Fern Bay Seaside Village Project Application

Further Response to Submission Report

Aspen Group
0063154 Final
April 2010
www.erm.com

Date:	7 April, 2010
Partner:	 Paul Douglass

3 OF 22

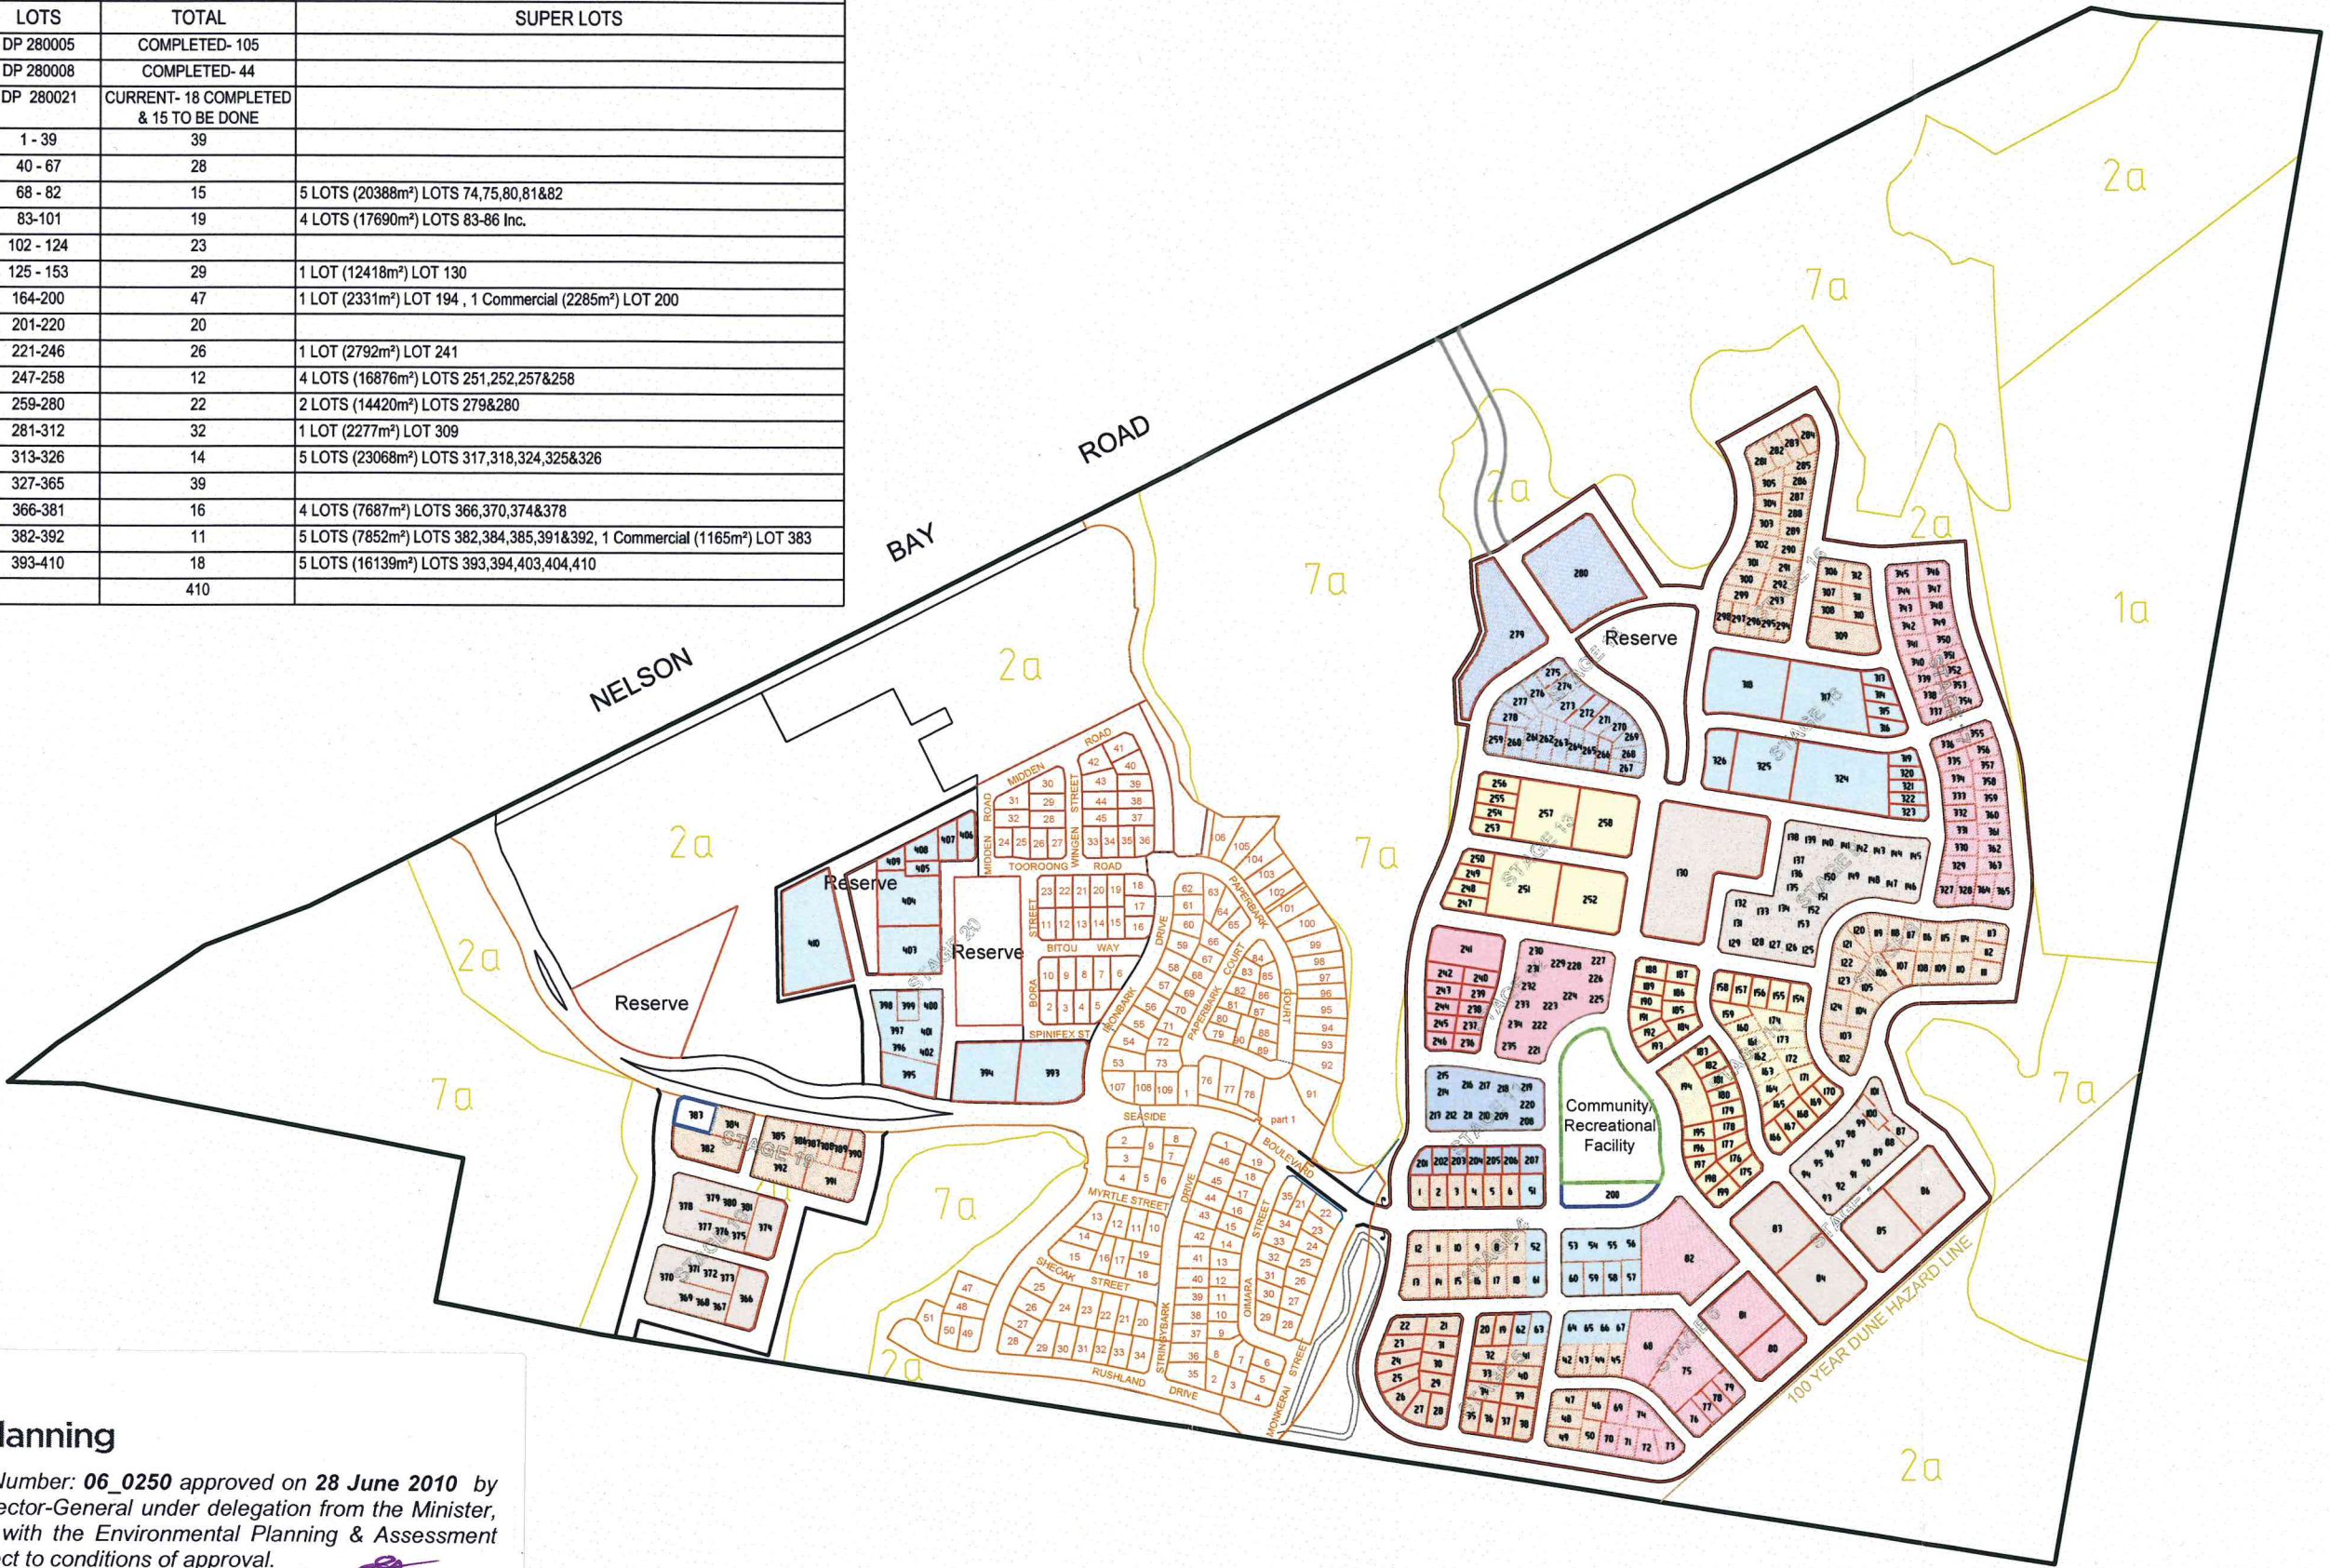
Authority	Issue Raised	Issue Ref	Submission	Response
Department of Planning	Subdivision layout and traffic	1	Port Stephens DCP 2007 requires a maximum street block length of 160 m (B1.C11). There are a number of proposed street blocks (within Stages 4,5,9 and 17) that do not comply and exceed the required street block length by up to 120m. The subdivision plan should be amended by reducing block lengths and providing additional connecting pathways (within Stages 4,5,9 and 17), which will assist in achieving compliance and also ensure pedestrian access/connectivity to open space and proposed bus stops are within 400m walking distance from any proposed lots. Please refer to submission from Port Stephens Council dated 01 February 2010, which provides suggested design amendments which could address this issue.	Subdivision plans have been amended to comply with Port Stephens DCP 2007 (see sheet 1 of 22 amended plan set 29850 A attached in <i>Annex B</i>).

Authority	Issue Raised	Issue Ref	Submission	Response
	Project Description	3	<p>the PPR)</p> <p>It is unclear as the exact number of lots for the development as the text in PPR suggests a total of 409 lots to be created in Stages 4-2, but the Site and Staging Plan prepared by Daly Smith Pty Ltd (Sheet 1 of 22 in Annex B) indicates a total of 410 lots in the table on the plan, of which, 38 are super lots (rather than 36 super lots).</p> <p>Provide confirmation on project description (which will be emulated in the final determination).</p>	<p>The preferred project description has been simplified to reflect the lot layout included attached in <i>Annex B</i> (see sheet 1 of 22 of amended plan set 29850 A).</p> <p>As stated in <i>section 2.3</i> the subdivision will be developed largely in accordance with Port Stephens DCP.</p> <p>To clarify, the preferred project description will be modified to include a total of 408 residential and 2 commercial lots constituting stages 4 to 20 of the Fern Bay Seaside Village. The subdivision is now proposed to include:</p> <ul style="list-style-type: none"> • creation of 370 residential lots; • creation of 38 super lots (residential); • creation of two commercial lots; and • creation of one community lot covering all land to be managed by the Community Association.

To meet this commitment the subdivision plans have been amended to improve connectivity through Stages 4, 5, 9 and 17 as recommended (see Annex B).

The preferred project plan description is to be modified to include a total of 408 residential and 2 commercial lots constituting stages 4 to 20 of the Fern Bay Seaside Village. The subdivision is now proposed to include:

- creation of 370 residential lots;
- creation of 38 super lots (residential);
- creation of two commercial lots;
- creation of one community lot covering all land to be managed by the community association.

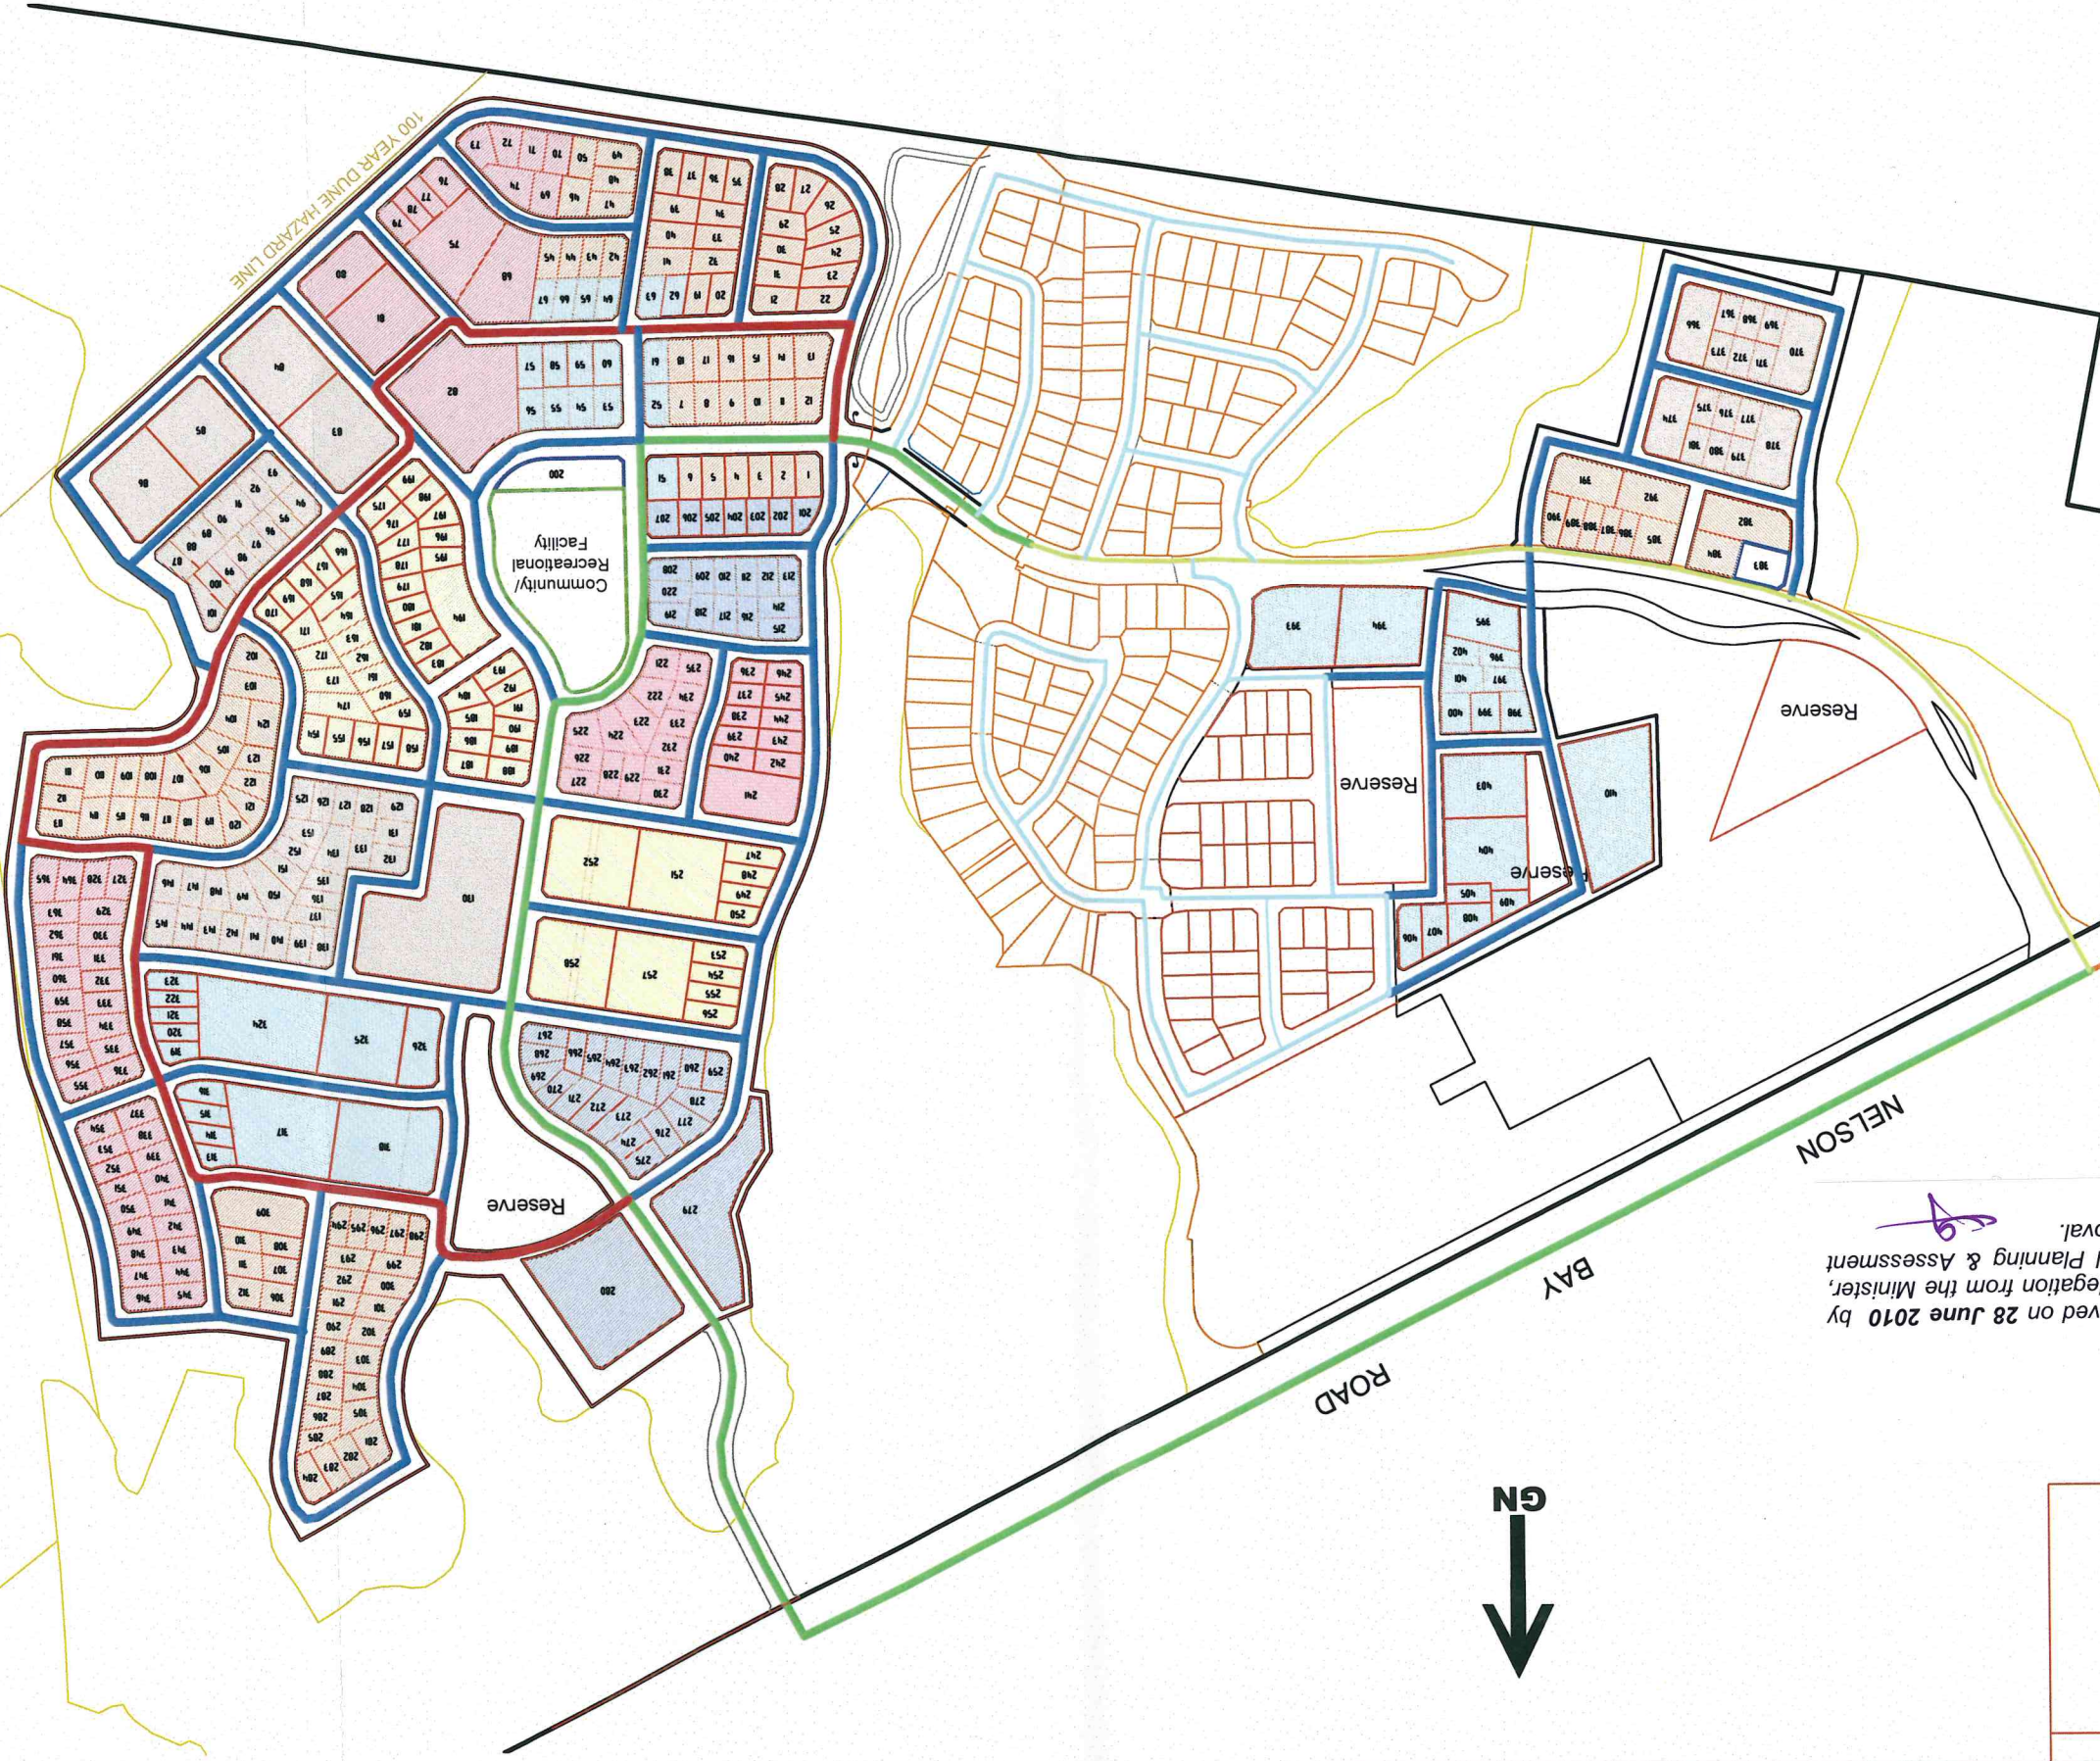
The Department requests a redesign of the subdivision layout which relocates Stormwater Basin 6 outside of Community Conservation Lands and within the development footprint due to the extensive amount of excavation and removal of vegetation required.

Stormwater facilities located on Community Conservation Lands	4	<p>Reference is made to proposed stormwater basin 1 and 6 outlined on plans provided in Attachment E of Amended Water Cycle Management Strategy' prepared by Martens Consulting Engineers dated December 2009 ('Martens Report') and Concept Site Drainage plan provided by Daly Smith (Annex B of the PPR, Sheet 15 of 22).</p> <p>Stormwater basin 6 will require an extensive amount of excavation, removal of 7285 sqm of vegetation and is located in proposed community conservation</p>	<p>See discussion in <i>section 2.4</i> of this report and amended report (April 2010) prepared by Dr Martens (<i>attached in Annex C</i>). This report responds to outstanding items and issues.</p>

In response to previous submissions relating to the provision of stormwater infrastructure on proposed community lands the proponent has significantly reduced the scale of infrastructure required. This has lead to a substantial reduction in the level of disturbance outside the development footprint shown in the Master Plan. The following description highlights the reduction in disturbance required for stormwater infrastructure:

- the level of disturbance for Catchment 1 is now approximately 434 m² reduced from 2500 m². No clearing of Swamp Sclerophyll Forest on Coastal Floodplain community will be required to be cleared for stormwater infrastructure;
- disturbance for stormwater infrastructure for Catchment 4 has been reduced from 10 000 m² to 2785 m², with 2020 m² of batters to be revegetated;
- disturbance for stormwater infrastructure for Catchment 5 has been reduced from 7800 m² to 1755 m², with 1310 m² of batters to be revegetated; and
- disturbance for stormwater infrastructure for Catchment 6 has increased marginally from 6900 m³ to 7285 m², of which 2,850 m² will be revegetated.

The total area of disturbance for stormwater infrastructure outside the development footprint endorsed by the approved Master Plan has therefore been reduce by more than half from 27 200 m² to 12 259 m².

The Preferred Project Plan application, including infiltration basins as outlined in amended plan set 29850 A, Sheet 22 of 22 in *Annex B*, delivers greater connectivity in terms of this wildlife corridor over what is envisioned in the Port Stephens Local Environment Plan 2000 (LEP 2000) where a large portion of the corridor between the bare dunes of Stockton Bight and Nelson Bay Road are zoned for Residential 2(a) and therefore urban development is permitted with consent.
